ASSESSMENT REPORT

Block 11 - Central Park, Chippendale SSD 6376 MOD 5

The application has been lodged by Frasers Broadway Pty Ltd (the Applicant) pursuant to section 4.55(1A) of the *Environmental Planning and Assessment Act 1979* (EP&A Act). It seeks approval for the removal of plant equipment on Level 13 to be replaced by 2 x one-bedroom apartments. The modification also seeks approval for several minor internal and external changes.

**Figure 3** - Level 13 as approved under SSD 6376 (source: Applicant's EIS)

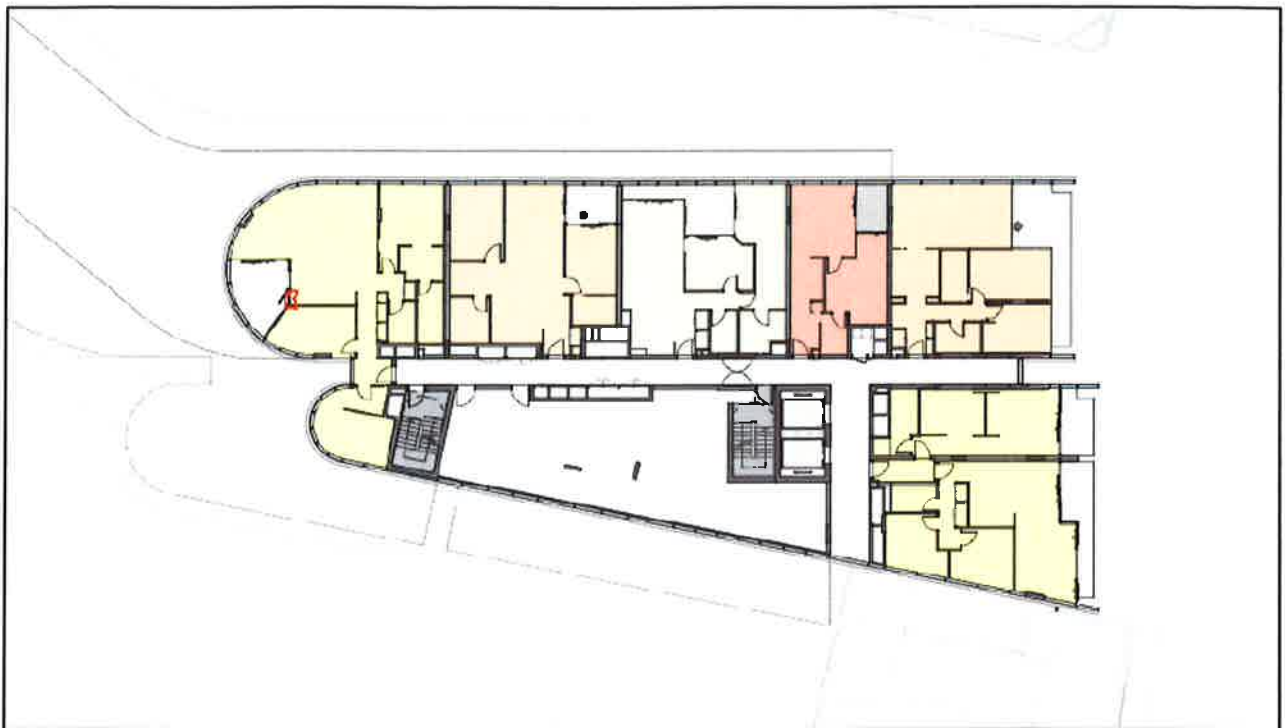
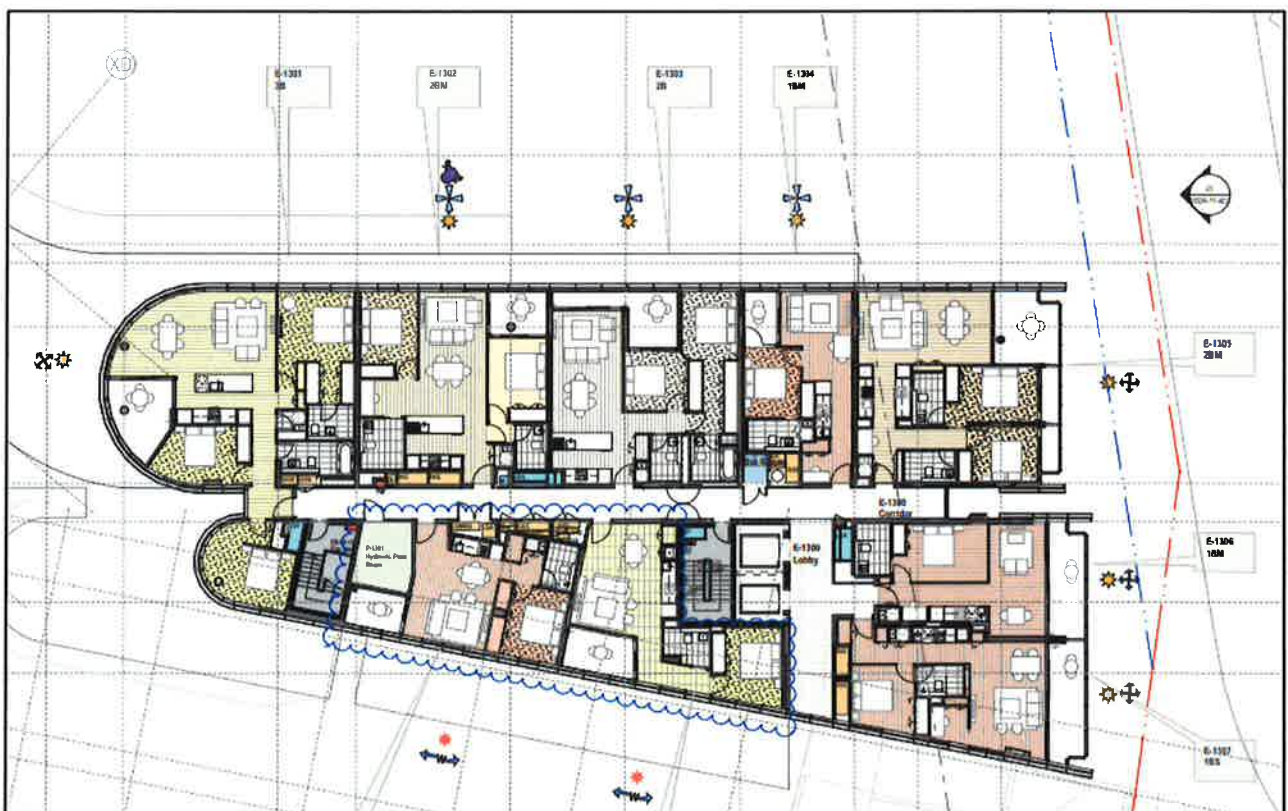
Built Form	<ul style="list-style-type: none">• The proposal seeks approval to remove the building plant located within Level 13 and replace it with 2 x one bedroom units (see Figure 4). This would increase the total number of units within Block 11 from 293 units to 295 units.			No additional conditions or

Issue	Consideration	Recommendation
	<ul style="list-style-type: none"> The Applicant notes that a significant portion of the approved plant area on Level 13 was originally intended to accommodate heat rejection equipment for the retail, childcare and community spaces. Most of this area however, is no longer needed because it will be connected to the precinct's central thermal plant which will enable more efficient heating and cooling of the building. The Department considers the proposed modification to Level 13 is acceptable as it would not change the height, bulk or scale of the approved building and it would not result in any adverse environmental impacts on adjoining neighbours. Further, the connection of the building to the precinct's central thermal plant will enable more efficient heating and cooling of the building, improving its sustainability. 	amendments necessary.
<i>Residential Amenity</i>	<ul style="list-style-type: none"> The Applicant provided a detailed assessment of the proposal against SEPP 65 and the provisions of the ADG. The assessment demonstrates the additional units generally maintain compliance with the ADG. In particular, the Department notes Units E1308 and E1309 are 53 m² and 50 m² in area, respectively. This meets the minimum size requirement of 50 m² for one bedroom apartments in the ADG. However, the Department notes Unit E1309 proposes a balcony 0.5 m² below the minimum of 6.5 m². The Department considers this is a minor non-compliance and the proposed unit would otherwise have an acceptable layout, outlook and comply with the requirements of the ADG. The Department therefore considers the new apartments would achieve acceptable levels of residential amenity. 	No additional comments or amendments necessary

Figure 3- Proposed retail signage to ground floor – northern elevation looking south down Kensington Street

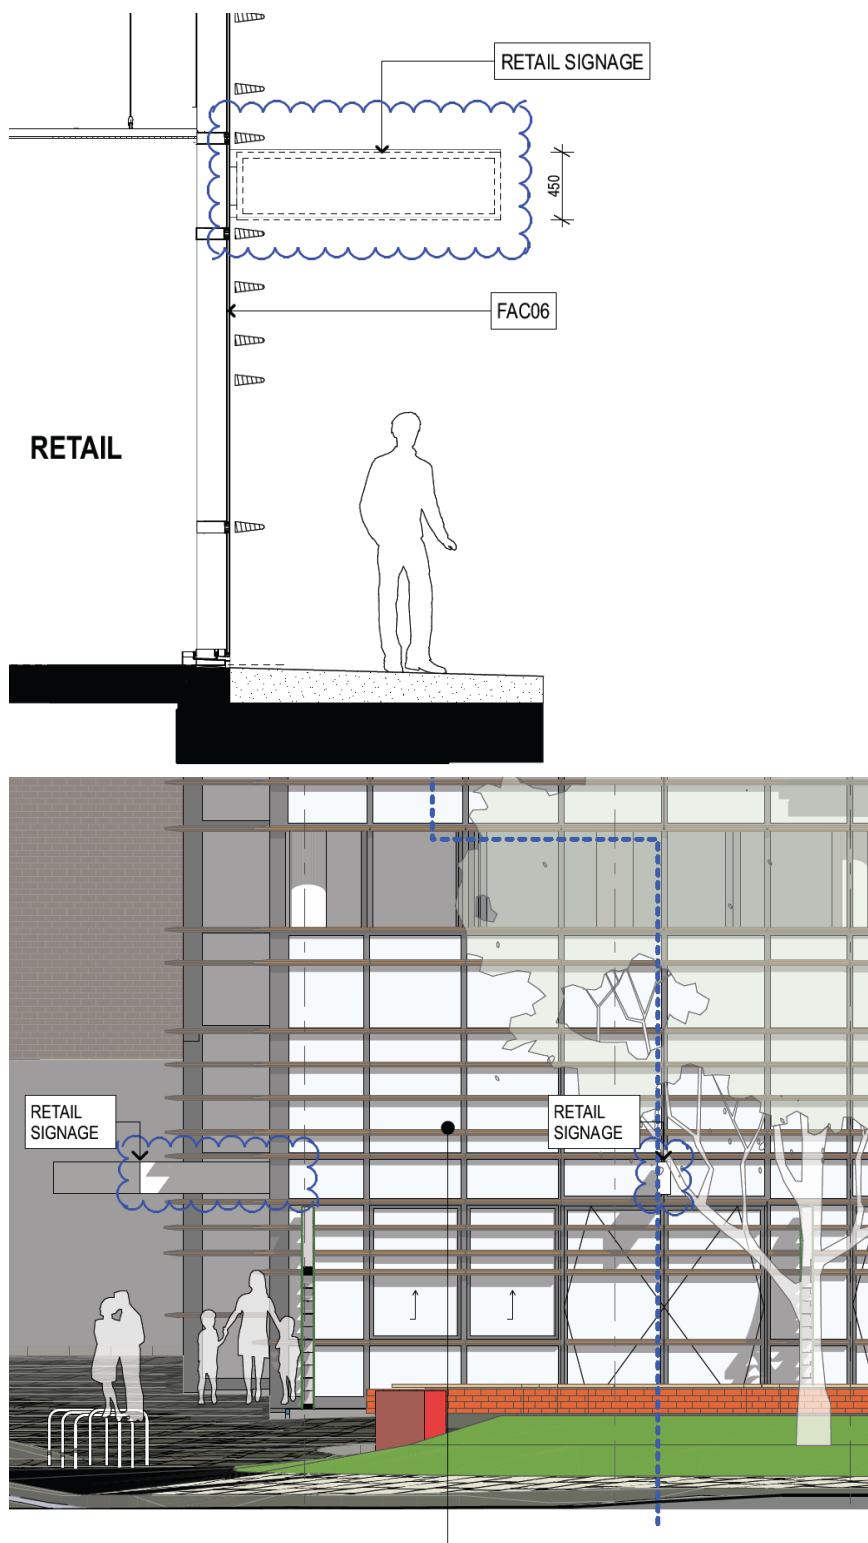
- the addition of two apartments is suitable as there is no increase in overall building height
- the proposed projecting signage should be reduced in size (to be less than 0.5 m²) and elevated to 2.6 m above ground level to comply with Council's signage guidelines.

<i>Ground Level Retail Tenancies Signage</i>	<ul style="list-style-type: none"> The proposal seeks approval for five projecting wall signs on the Ground Level above the retail tenancies. The signage will comprise illuminated light boxes affixed to the retail tenancy façades. The proposed signs are 450 mm high and 1750 mm wide. Council has expressed concern that the proposed signage does not comply with its signage guidelines. To achieve compliance, Council requires the proposed signage to project no more than one metre from the façade, be elevated to 2.6 m above the ground level of the footpath and be less than 0.5 m² in area. The Applicant notes that indicative signage zones were approved under SSD 6376 and the proposed signage is consistent with other signage in the Central Park precinct. However, the Department notes Condition A6 states that the consent does not approve signage and 'separate approval/s for the fit out of the building and signage to be obtained for this development/use if required by the EP&A Act'. Accordingly, the consent cannot be modified to include signage as it was not approved in the original application. As such, the Applicant will need separate approval/s for the signage in accordance with the requirements of Condition A6. 	No additional comments or amendments necessary
